PROJECT TITLE Retail Stores and Warehouses TYPE OF SUBMITTAL Drainage Plan
ZONE ATLAS PAGE NO. H-21 CITY ADDRESS 9809 Menaul Blvd., NE
LEGAL DESCRIPTION Lot 7A/ Block 43 Snow Heights Addition
ENGINEERING FIRM Geotechnical Research CONTACT Duane Logan
ADDRESS 501 Kinley, NE PHONE 247-0102
OWNER Sierra Alto Company CONTACT Fred Galley
ADDRESS 5321 Menaul, NE PHONE 883-0414
ARCHITECT Roger Cinelli CONTACT James Madley
ADDRESS Box 965, Tijeras, NM PHONE 842-5892
SURVEYOR Geotech Research CONTACT Duane Logan
ADDRESS 501 Kinley, NE PHONE 247-0102
CONTRACTOR La Sierra Const. Co. CONTACT Pete Daskalos
ADDRESS 5321 Menaul, NE PHONE 883-0414

REF: DRAINAGE PLAN FOR RETAIL STORES & WAREHOUSES (H21-D19) RECEIVED
FEBRUARY 6, 1984

REF: GRADING AND DRAINAGE PLAN FOR OFFICE AND WAREHOUSE COMPLEX
(H21-D19) RECEIVED MARCH 19, 1984

GEOTECHNICAL RESEARCH & SERVICES, LTD. 601 KINLEY, NE - ALBUQUERQUE, NEW MEXICO 87102 (505) 247-0102	
OFFICE AND WAREHOUSE COMPLEX File # H83-8 For: SIERRA ALTO COMPANY Date 11-30-83 At: 9809 MENAUL BLVD., NE Drawn: RN/CLL DRAINAGE PLAN Sheet 1 OF 2	H21/D19

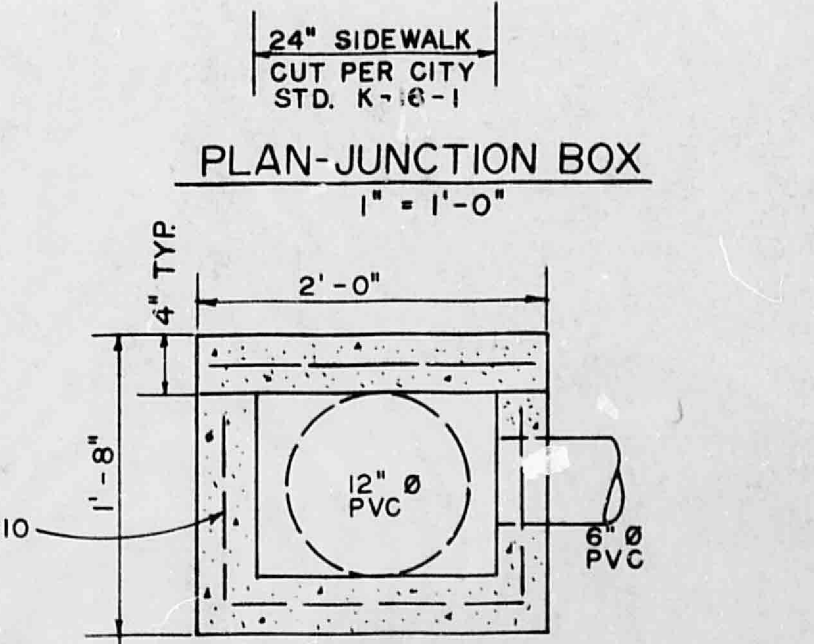
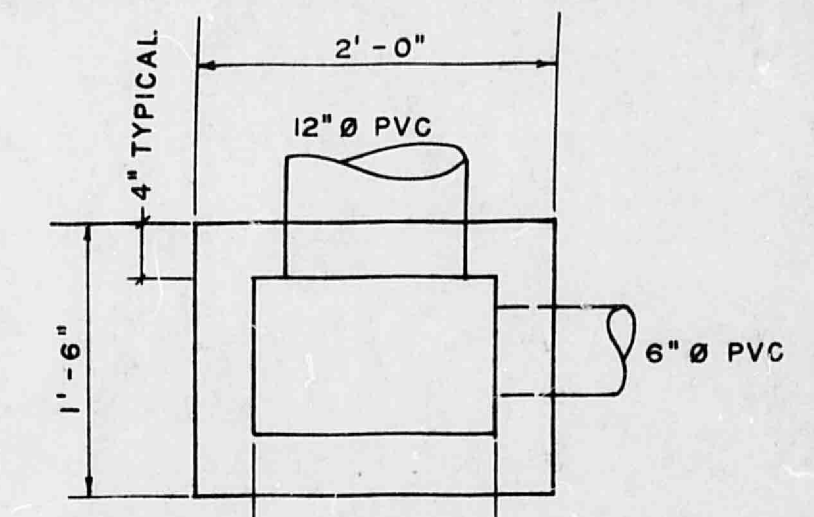
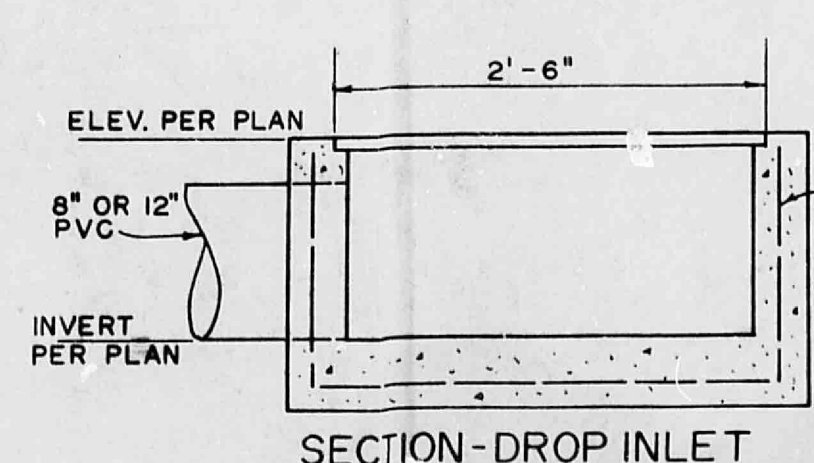
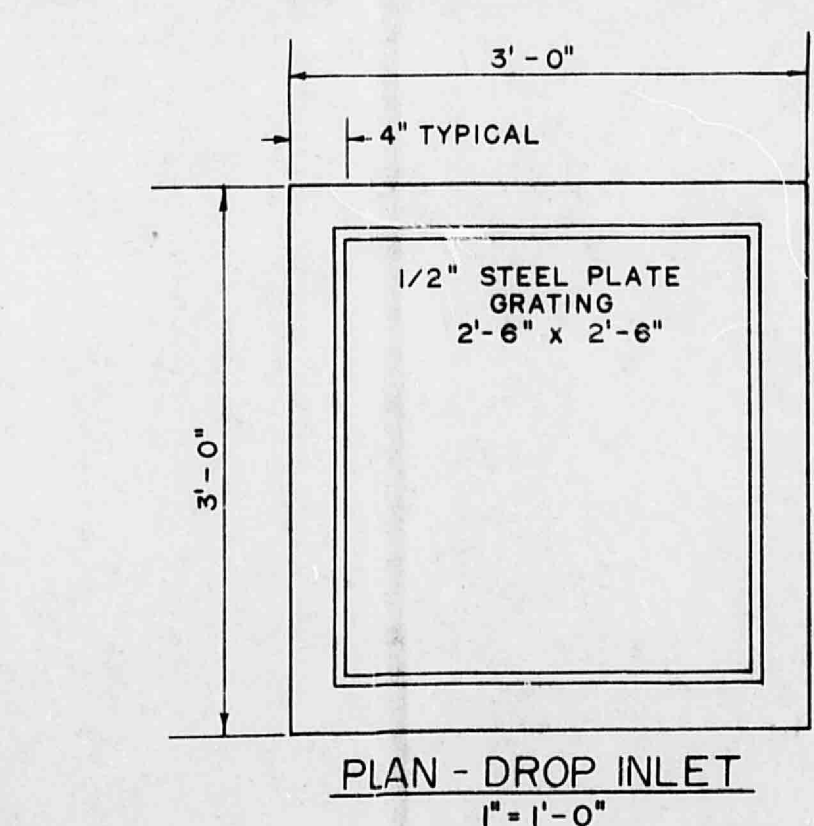
I have reviewed the above referenced submittal and at most all I can give is conceptual approval. You have not provided any hydrological or hydraulic information to give it any further review.

The above referenced submittal is in compliance with my request.
Therefore, the drainage plan for this site is approved.

Please attach a copy of the plan, dated November 30, 1983, to the
construction set prior to issuance of the building permit. Also
attach a copy of the approved "Construction Within Public R/W"
document.
